Subject: RE: Planning Consultation on: BN/84/20/PL

Response to Planning Application

Application ref: BN/84/20/PL

Location: Land At Angels Nursery Yapton Road Barnham PO22 0AY

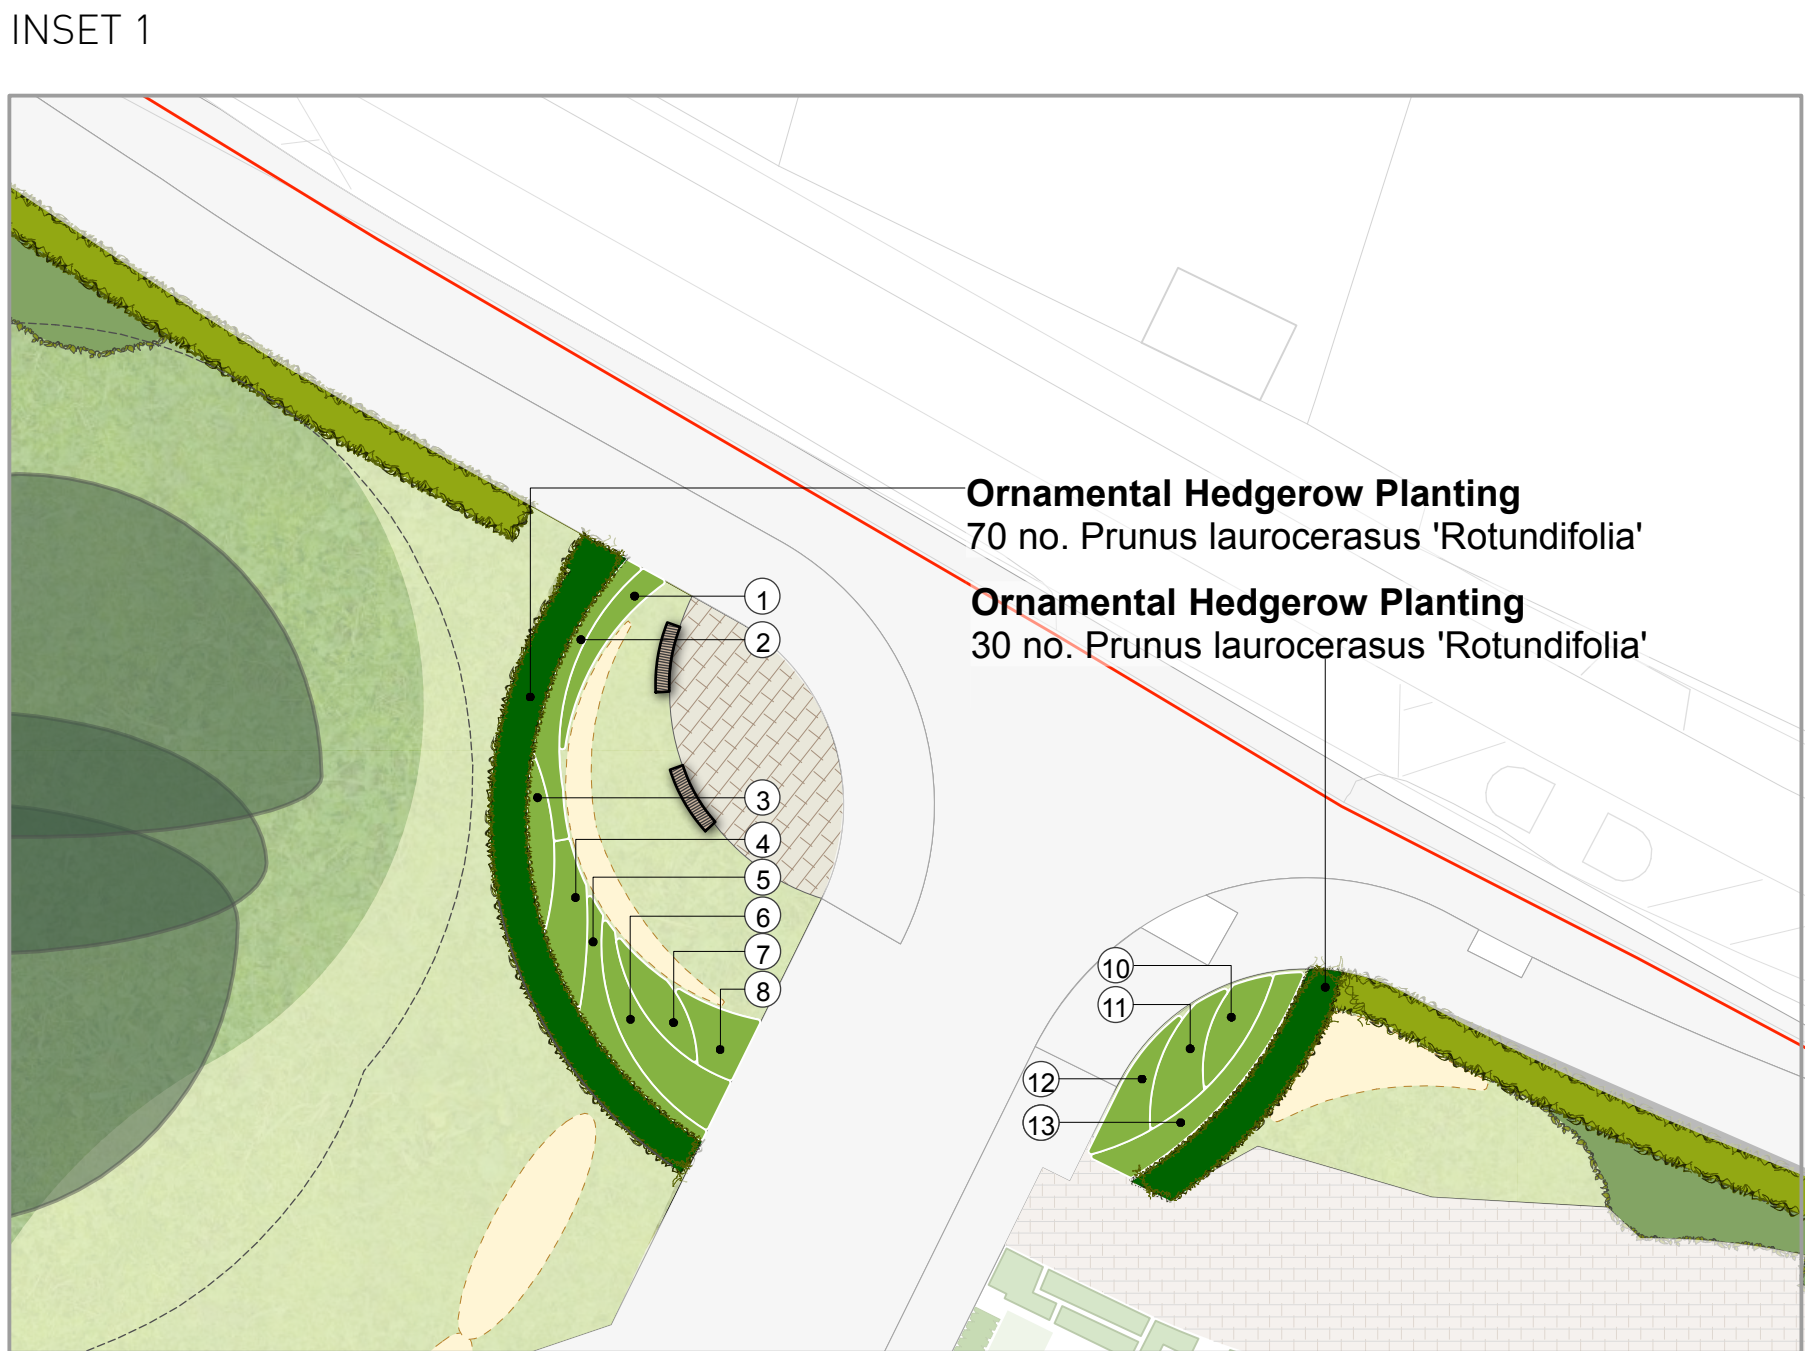
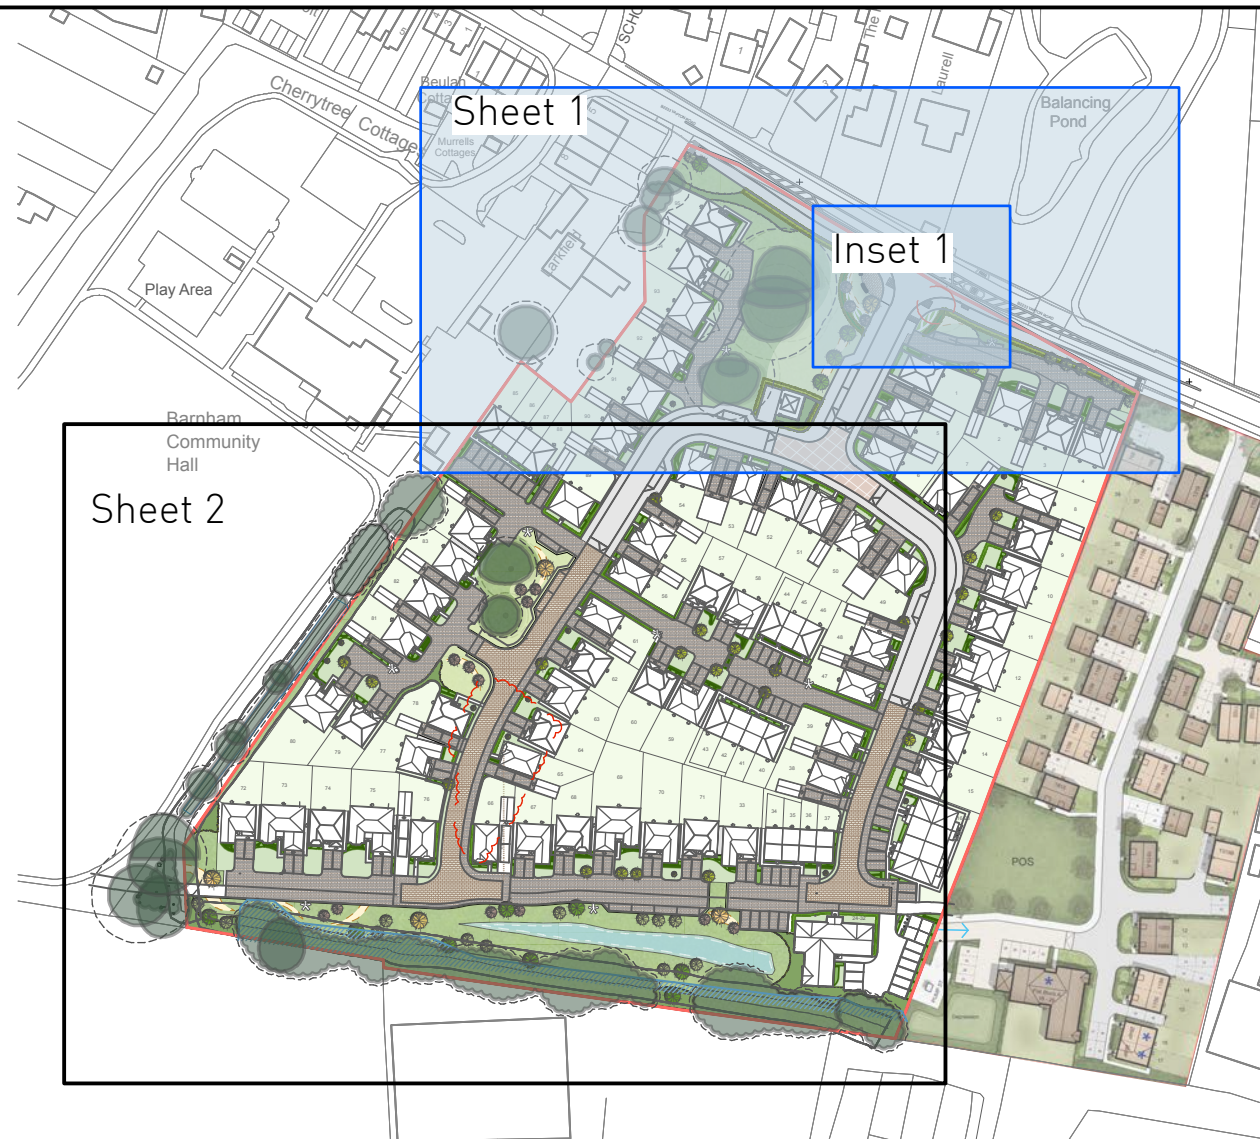
Forming part of the application and prior to any consent being given a full landscape scheme should be submitted for approval, detailing species choice, position, densities and size at time of planting. This should be plotted in plan and list form and in relation to the trees and vegetation to be retained in the locale, so that a clear picture of the proposals can be seen. These details are required to assure the adjacent land setting is maintained, the setting is uncompromised, and the proposals are appropriate to its setting. The retained vegetative areas to the periphery of the site would create wildlife corridors and for the retention of valuable established vegetation.

Further detail beyond layout would need to be submitted for approval re onsite SuDS features, detailed landscape proposals and onsite play provision.

Detailed landscape provision would need to be submitted for approval to include green boundary treatment, plot and POS provision. All areas should be considered and their connection for biodiversity and habitat explored. Trees specified should be at a size which allows instant impact, but which will establish and mature as the site develops.

**ANGEL'S NURSERY, BARNHAM - PUBLIC OPEN SPACE PLAN**

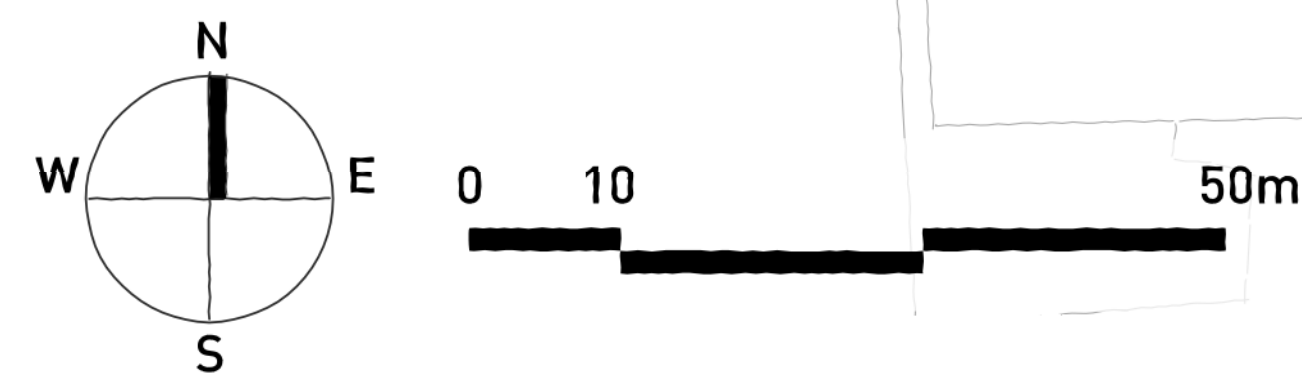
Summary recommendation: Recommendation relating to this application re approved plans under BN/84/20/PL Greenspace would still uphold a Landscape objection to the quantity of POS being offered, albeit layout positioning not having changed significantly from the original application. The provision of SuDS areas and no clear detail of the nature of these and therefore the potential to further deplete the usable POS within this development would conclude that POS provision within the site does not meet our SPD requirements and therefore would have to be recommended as a Greenspace objection.

I have viewed the relevant landscape detailed contained under this application BN/84/20/PL I can confirm that Greenspace objects to the quantity of Public Open Space (POS) being proposed, albeit layout, positioning not having changed significantly from the original approved application. The provision of SuDS areas and no clear detail of the nature of these and therefore the potential to further deplete the usable POS within this development would conclude that POS provision within the site does not meet the ADC Open Space SPD requirements.

The site has previously been determined under application Bn/43/16/PL Greenspace consultation comments were sought at that time and subsequently revised, comments which I reiterate below. In general, the layout was recommended as insufficient in POS (Public Open Space) particularly when the SuDS area was taken into consideration. The revised layout under this application BN/13/19/PL dwg no P19-0723-09 rev A has improved slightly in the overall quantity of POS being offered however the area of what we would deem unusable POS would still appear insufficient for 95 dwellings, with much of the large open area allocated to SuDS feature. Further detail re the nature of the SuDS and whether these are to be water holding bodies or dry features would clarify the offer. The POS has considered the existing trees within the site which is good to see, however the overall POS areas would appear somewhat disjointed with no valuable connectivity between them. There is no clear detail to show the connectivity for pedestrian and cycle routes within and beyond the site and how these also connect the POS areas. The conclusion of the layout shown would have to be a recommendation that the POS areas within the site are lacking, do not meet our SPD requirements and therefore would have to be recommended as an objection.

Developments of 10-200 dwellings or more are expected to provide open space on site. The Council's SPG guidelines which apply to developments of houses and are based broadly upon the National Playing Fields Association's (NPFA) "Six Acre Standard". Under superseded Fields in Trust guidelines (FIT) this requires that 3.2 hectares of open space are provided for every 1,000 people ie 32 square metres of open space per person. We would require confirmation of the areas of public open space being proposed with this development. As there are 95 dwellings proposed for this site, then provision of LAP and LEAP would be sought on site with the addition of Multi-Use Games Area (MUGA) contribution being sought. The present details indicate an on-site open space provision of 4652m², however 2289m² of this is indicated as retention basin and would not be suitable as open space. The open space indicated at present does not meet the minimum requirements.
